**Subject:** Upper South Creek Advanced Water Recycling Centre (SSI-8609189) Amendment Report

### Attachment 1 – EES biodiversity comments on the Upper South Creek Advanced Water Recycling Centre (SSI 8609189) Amendment Report.

#### *Sydney Region Growth Centres Biodiversity Certification - Kemps Creek re-alignment*

Figure 1 – Impacts to ENV

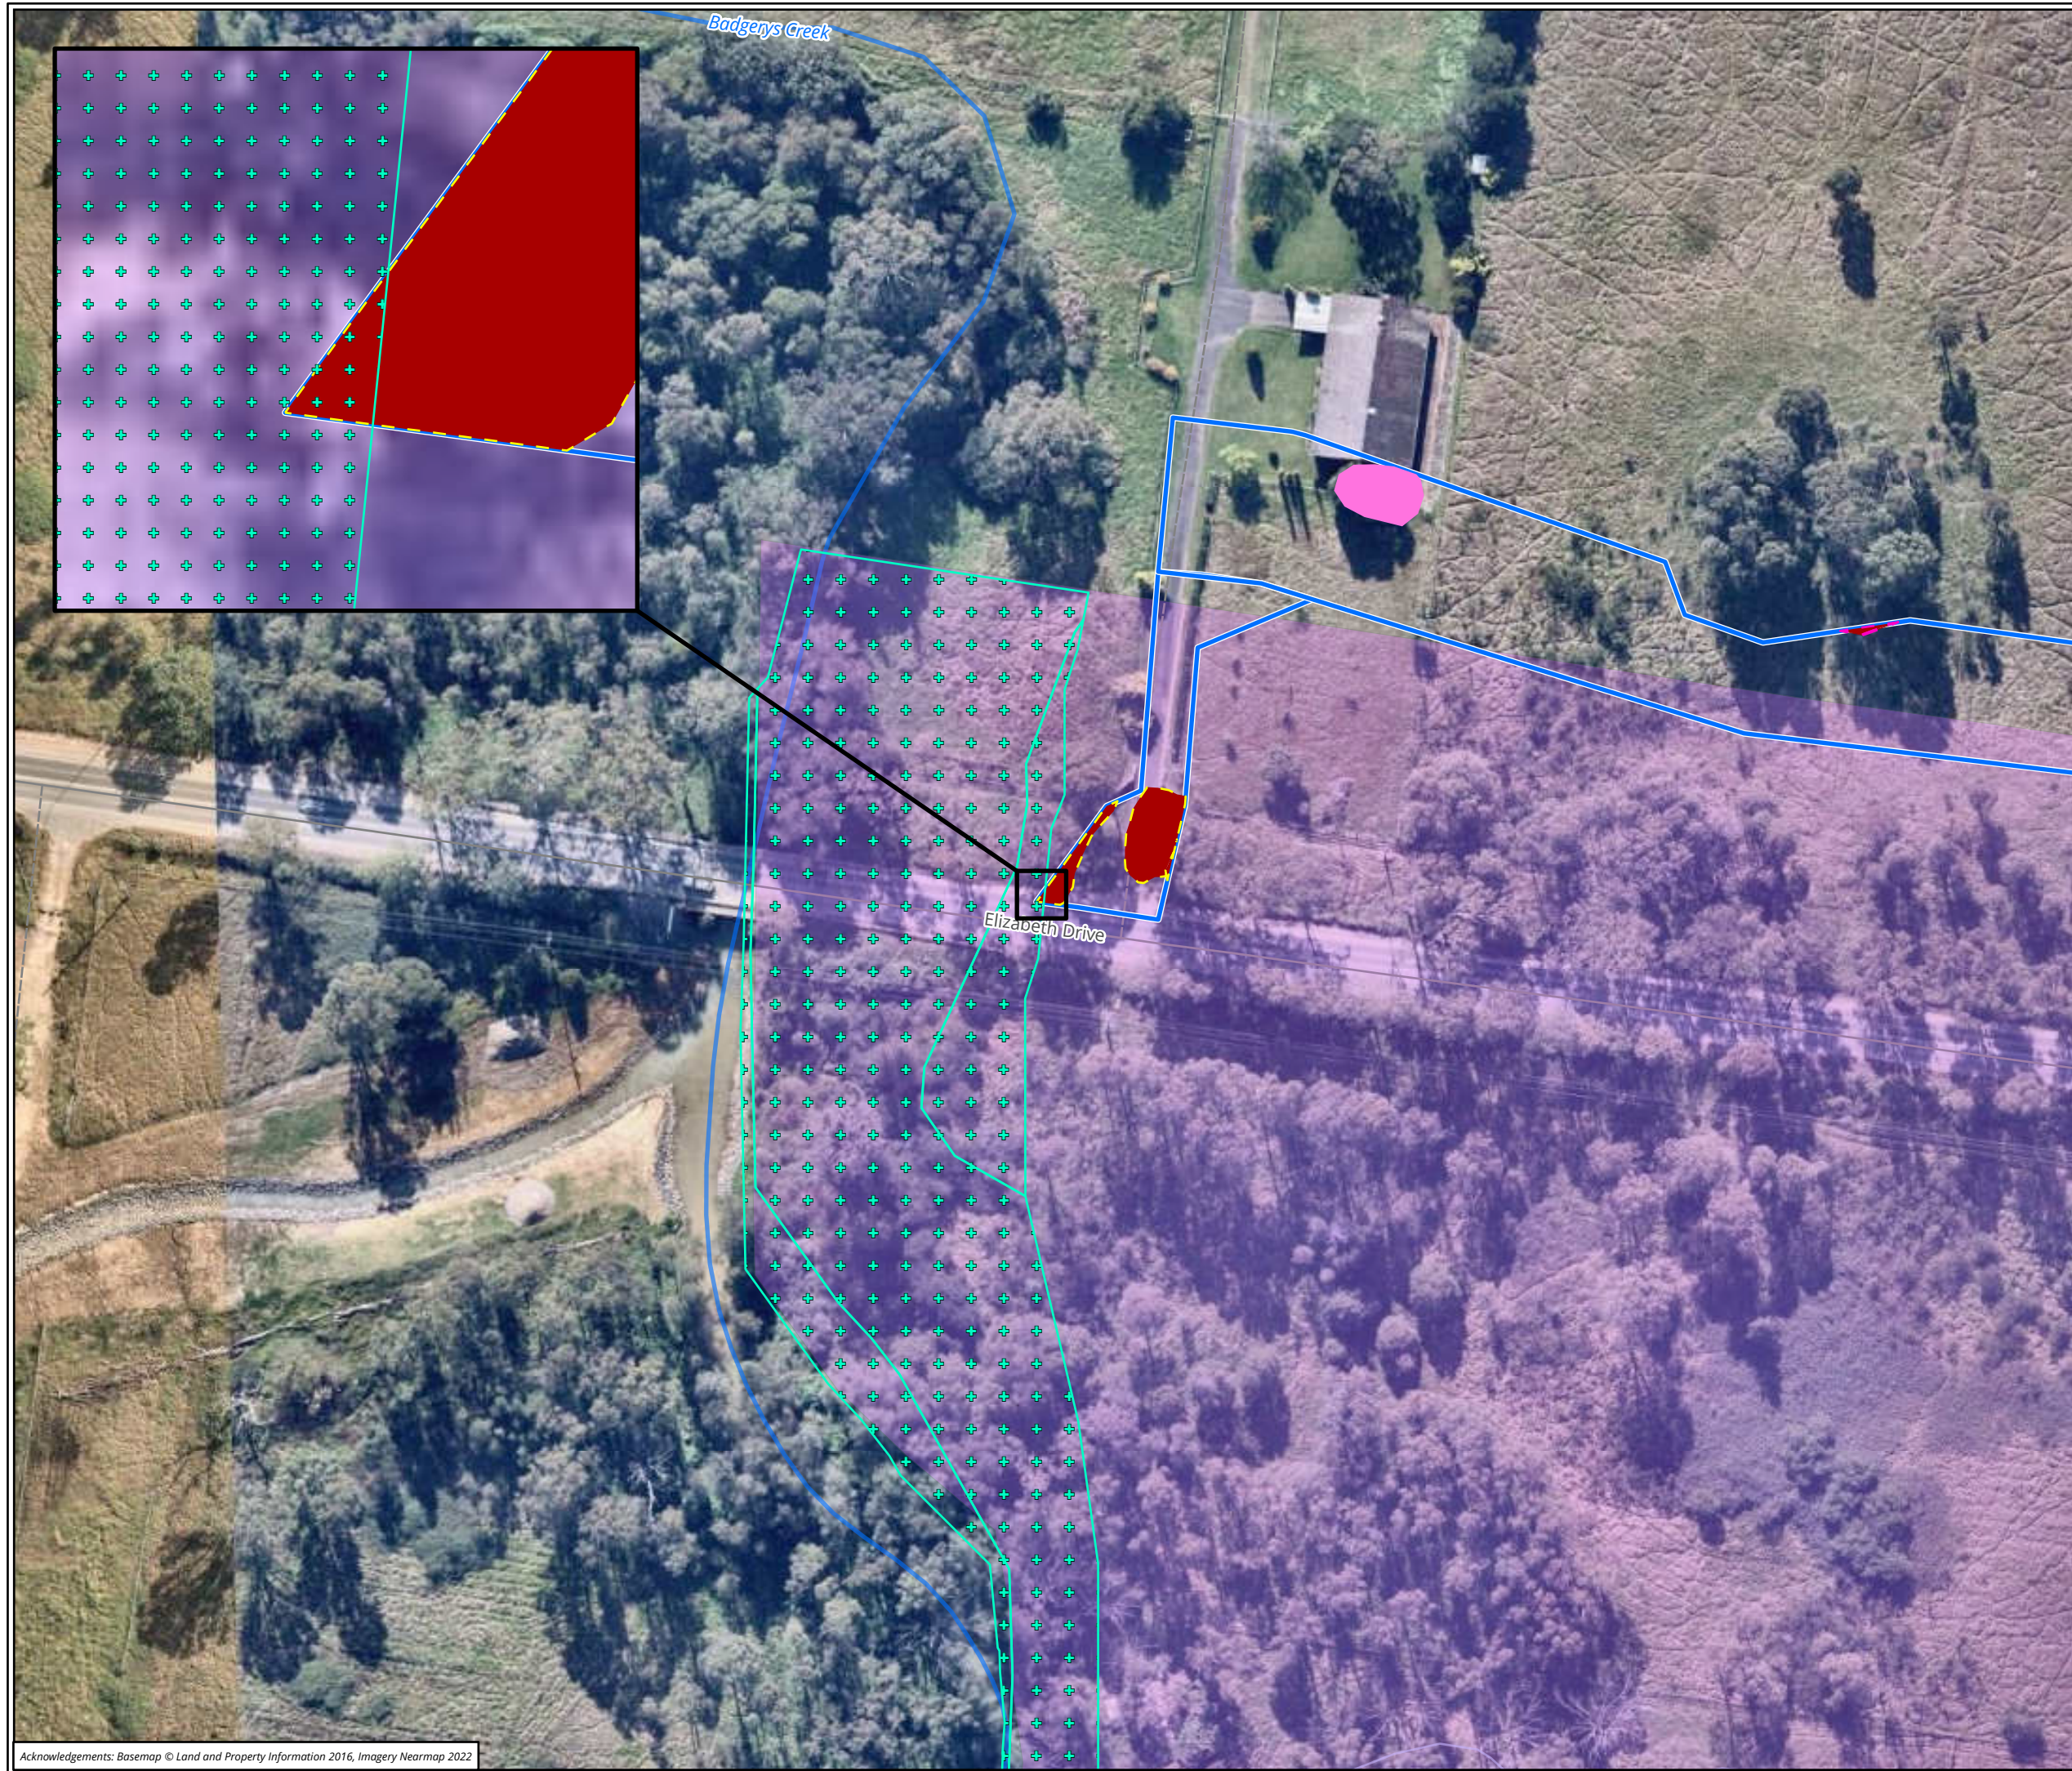
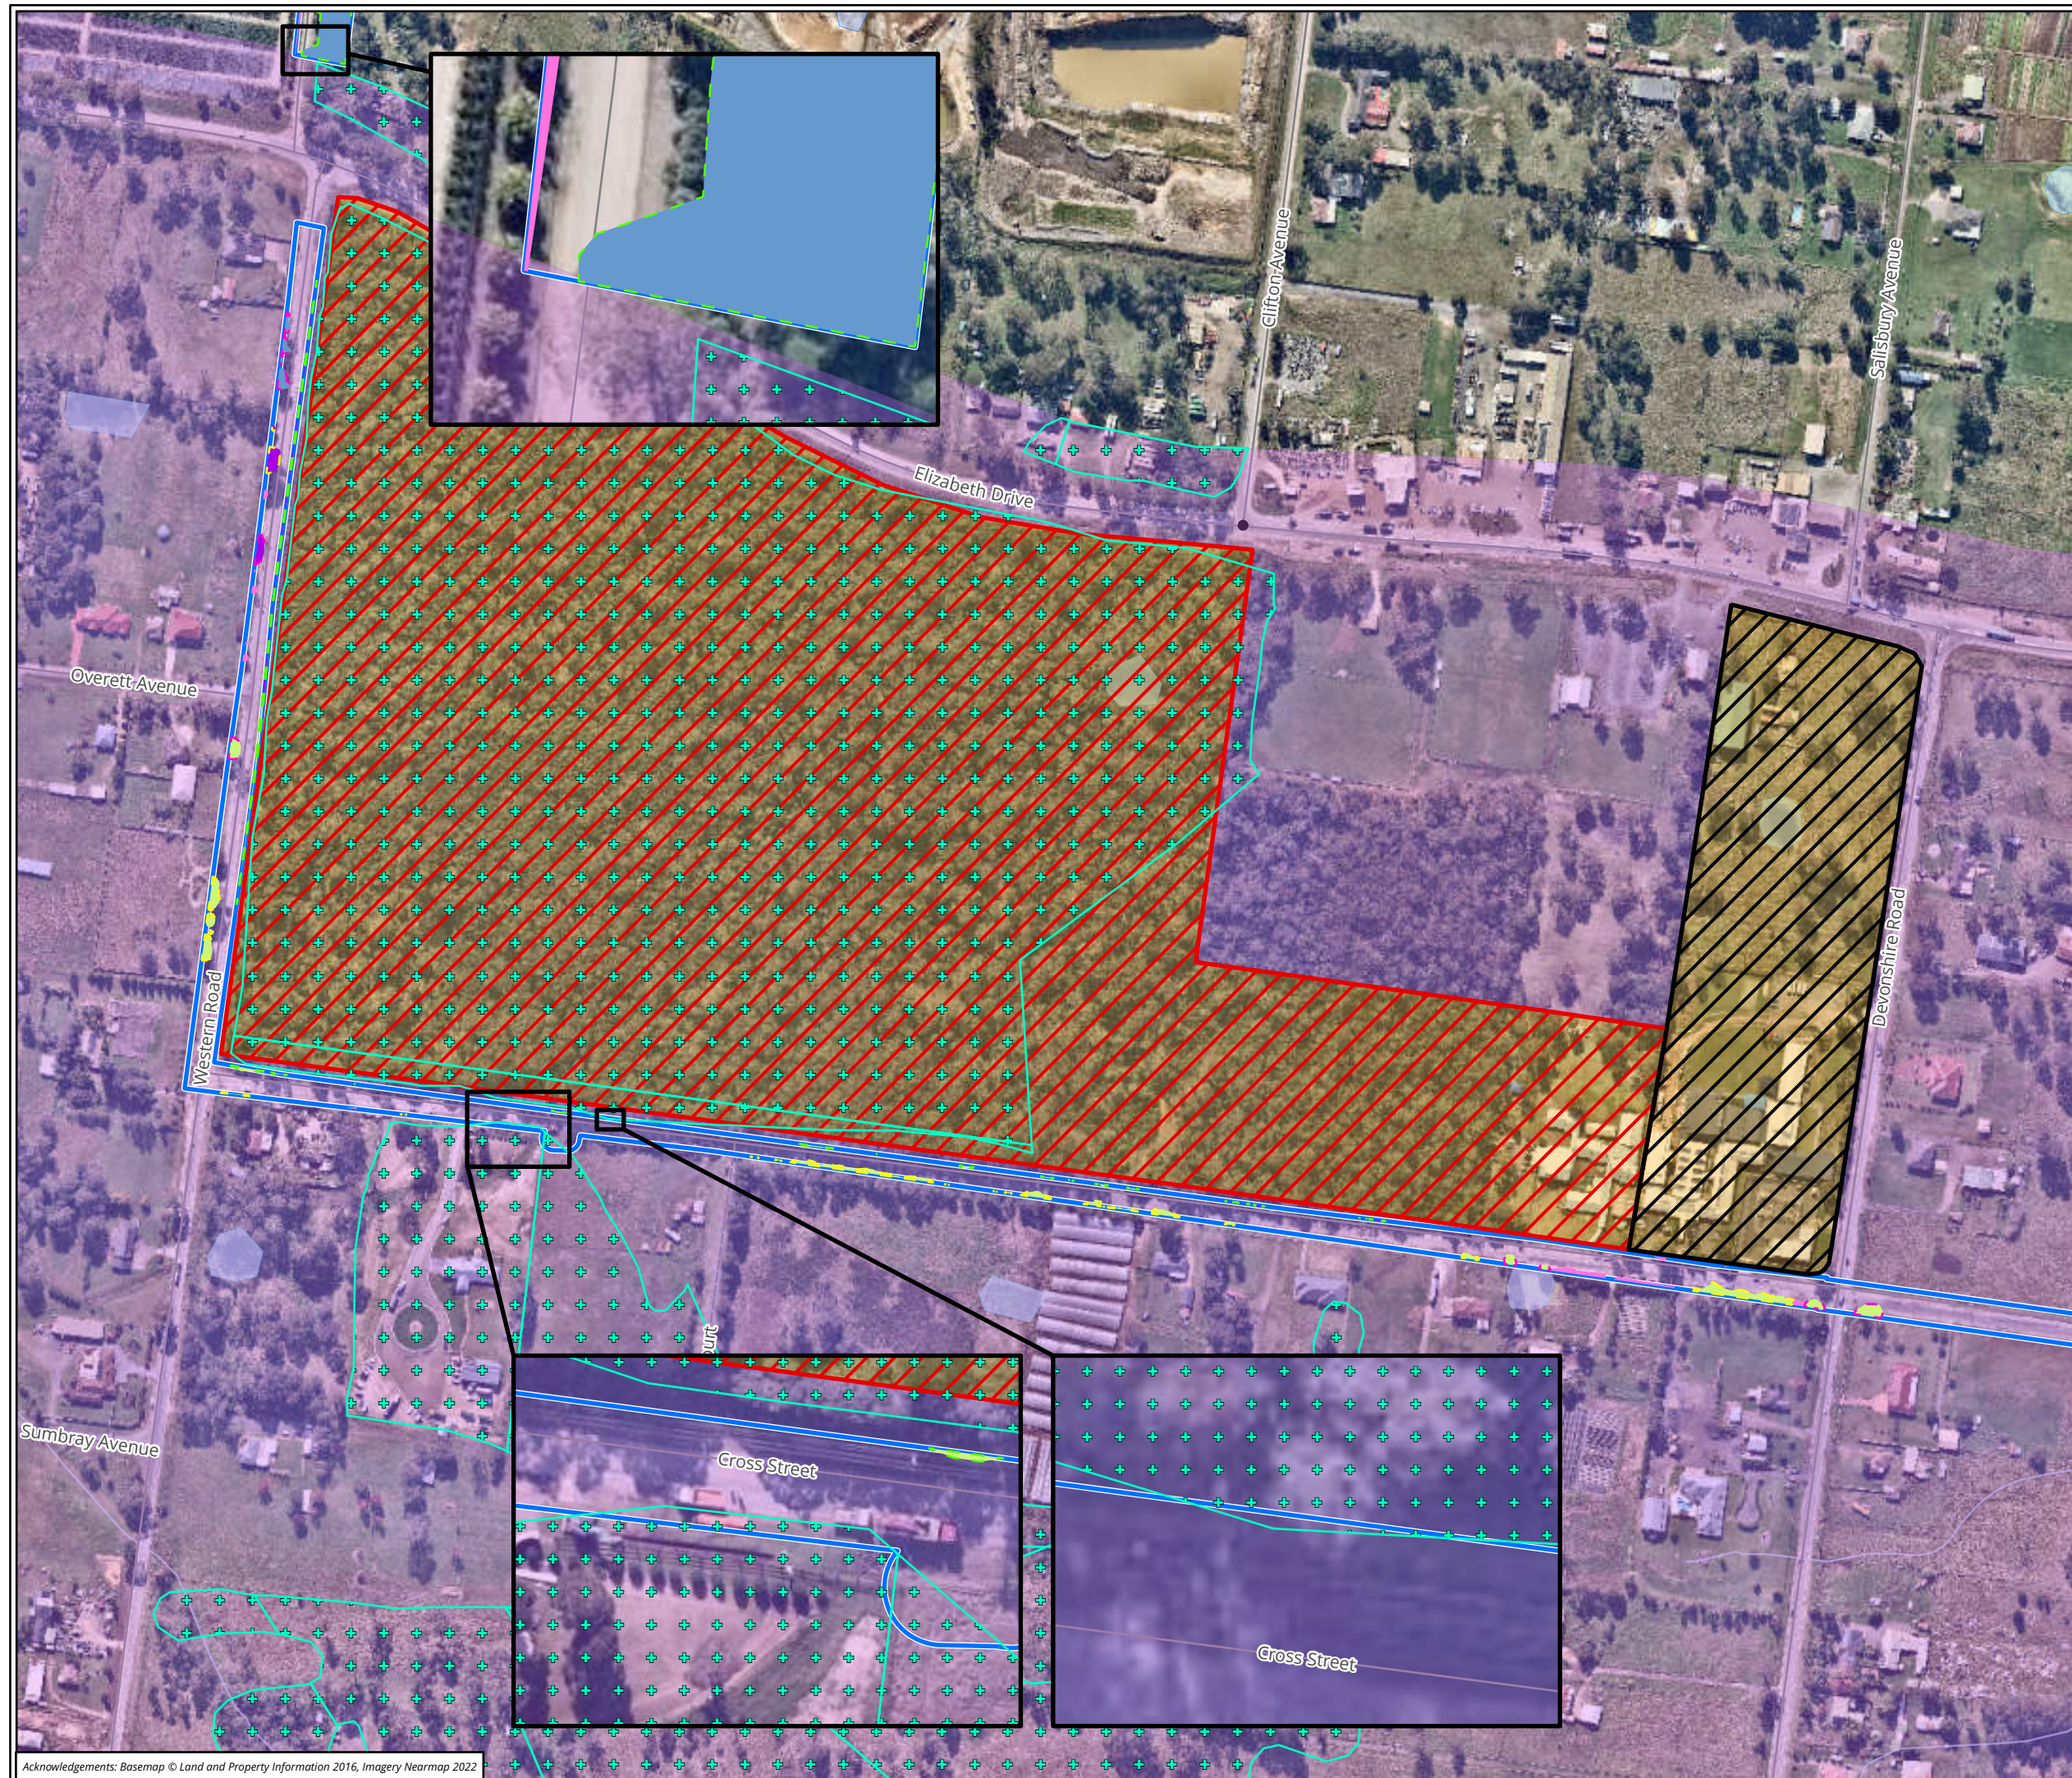
The Amendment Report proposes to realign and construct the AWRC pipeline to within this currently cleared corridor. EH seeks confirmation that no further impacts to ENV will occur from the proposed amended realignment and the pipeline construction and operation. The RtS report should include ENV on the maps in addition to the RMB 12 red hatched area.
